A1 Birtley to Coal House

Scheme Number: TR010031

Applicant's Responses to ExA's Second Written Questions - Appendix 2.10B - Flood Modelling response to Environment Agency Comments

DATE:	28 January 2020	CONFIDENTIALITY:	Public
SUBJECT:	Flood Modelling Response to EA Comments		
PROJECT:	A1 BCH	AUTHOR:	Chris Parker
CHECKED:		APPROVED:	Andy Smith

KINGSWAY VIADUCT (JUNCTION 67)  
EXISTING CROSS SECTION B-B  
SCALE 1:50

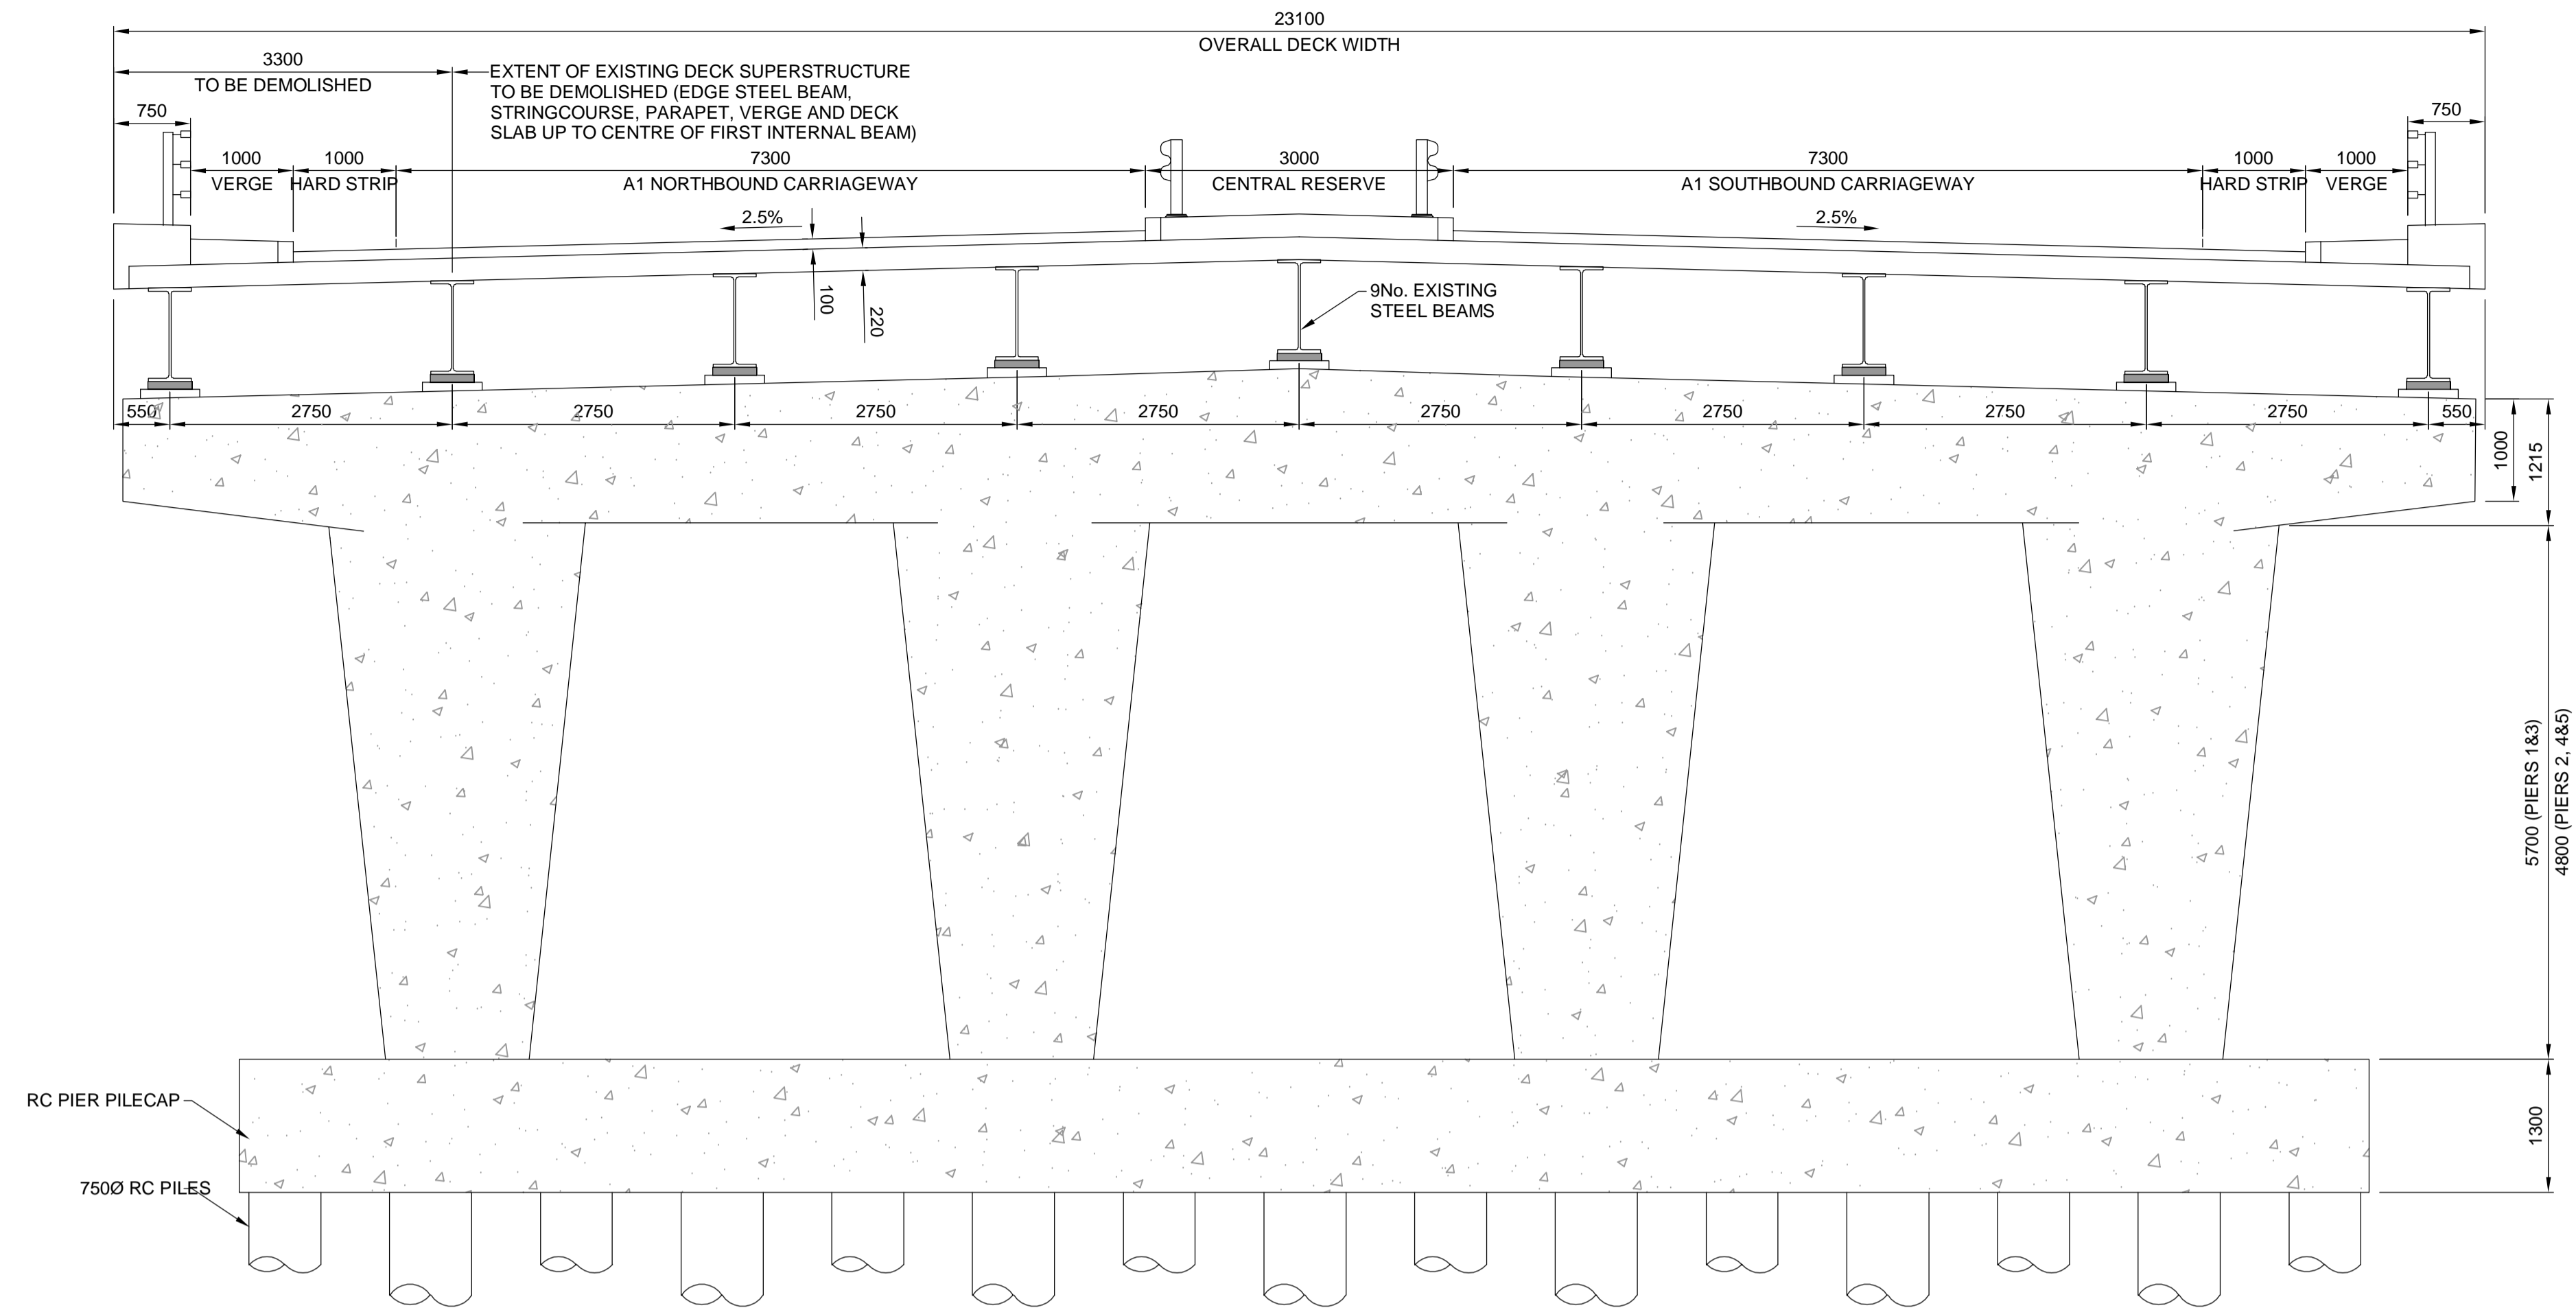
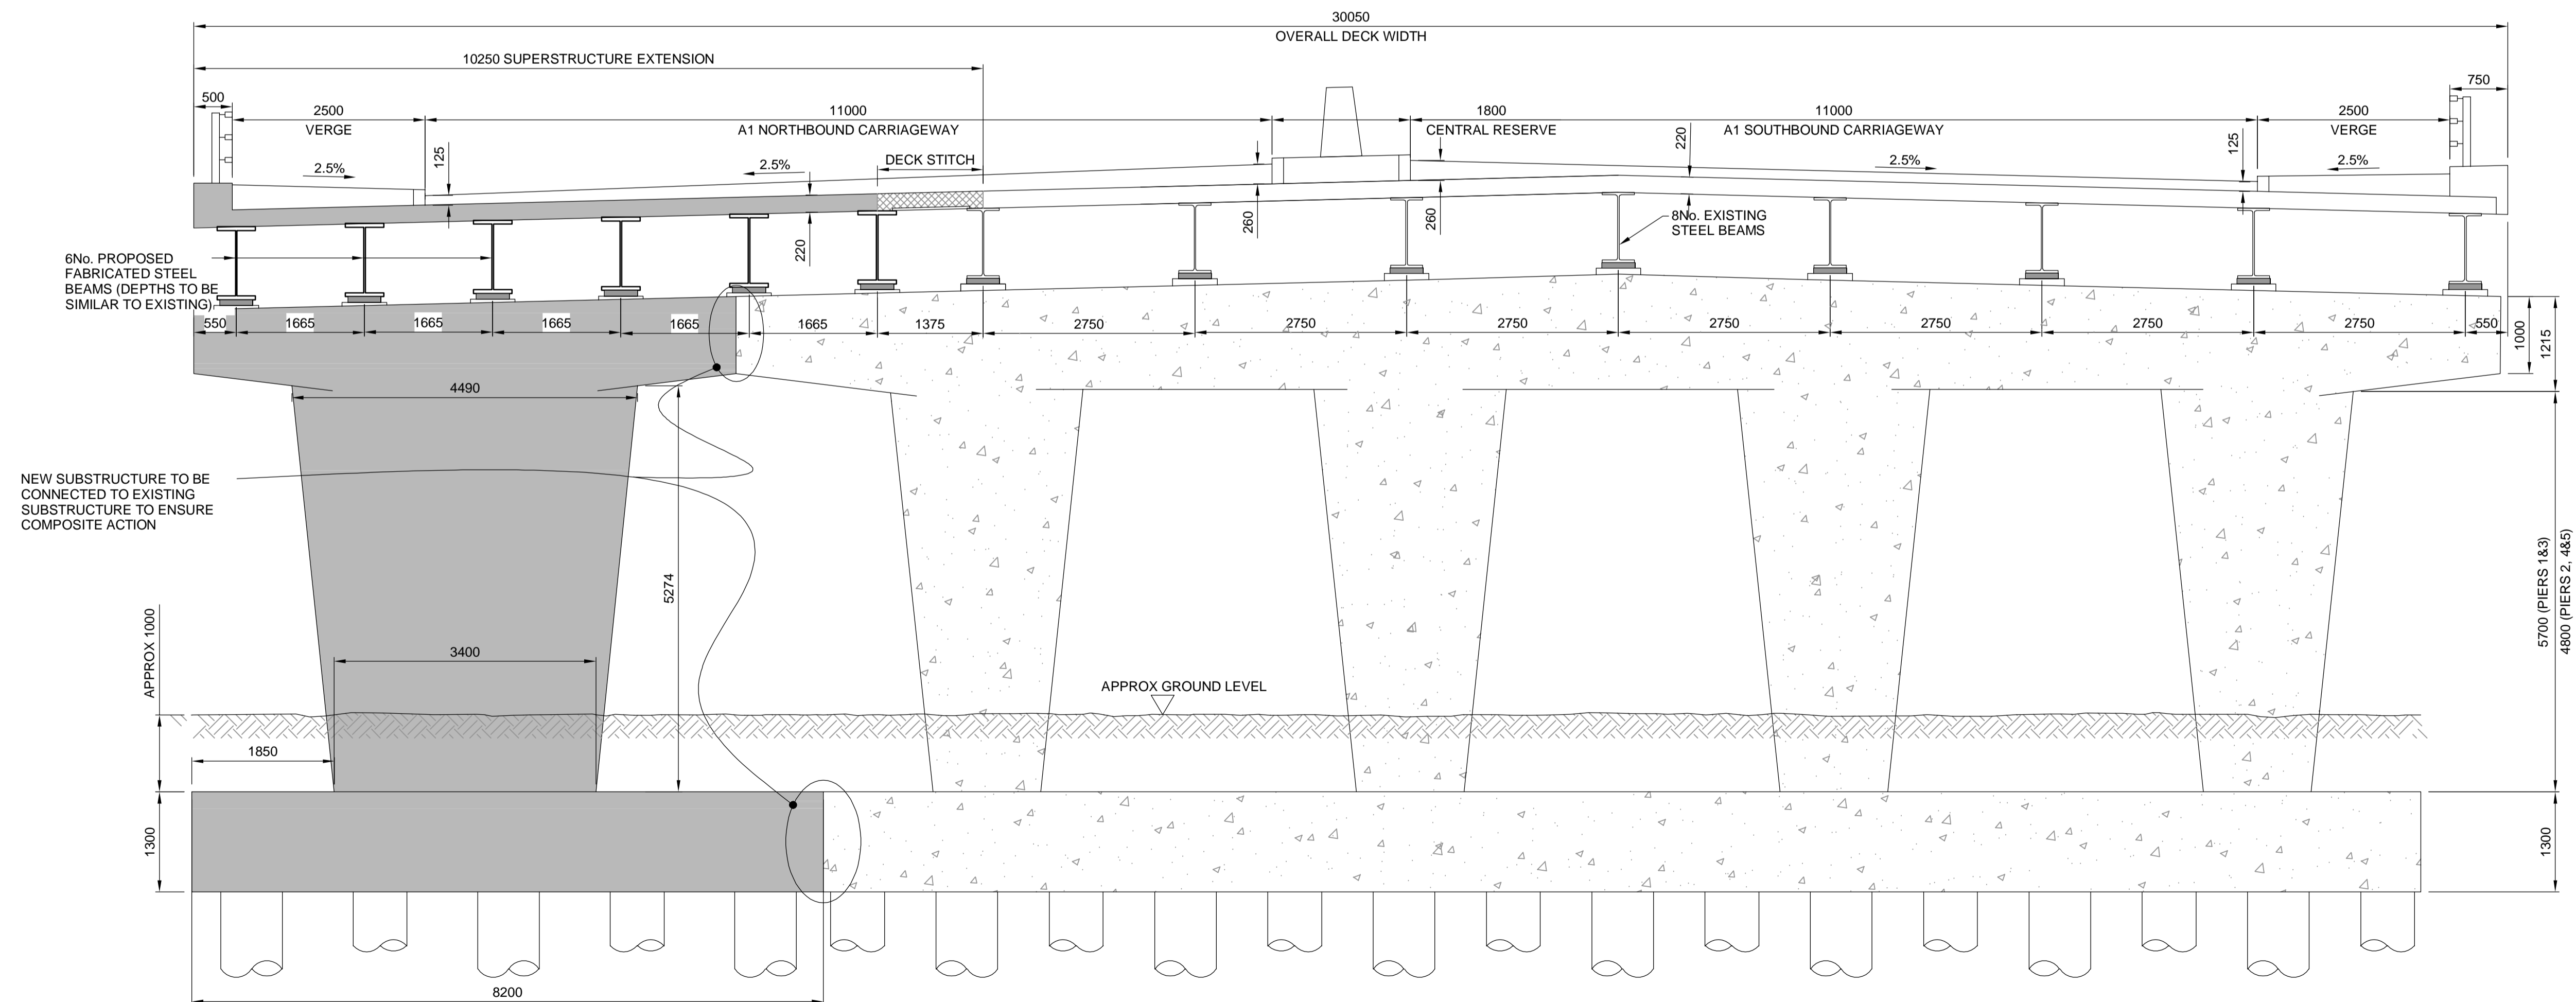
ID: B-29 MODEL STABILITY AND B-143 OUT OF BANK OSCILLATIONS

Lowering the bank line modular limit to 0.6 for the TEAM_5156.1 river reach improved left bank flow for the option model, as shown in Figure 4, but caused the original basemodel provided by the EA to fail. The change in modular limit had no impact on in channel flows. The stability problem seems to be a wider issue with the model for example, river reach TE05820.1 directly upstream of the Kingsway Viaduct, shown in Figure 5, shows significant oscillations to in channel and left bank flows. Resolving stability issues with the wider approved and provided Environment Agency model (as developed by JBA) is not required as part of

the evidence base for the Scheme. This is because the A1 is significantly elevated above the River Team and its associated floodplain at this point on a viaduct and the only impacts occur in the future climate change scenarios when the additional bridge piers require a small amount of floodplain compensation (12m³). The model is therefore considered suitable to assess the scale and nature of the proposed impacts.

An attempt was made to improve channel conveyance of river reach TEAM_5156.1 however, this resulted in the model failing to run.
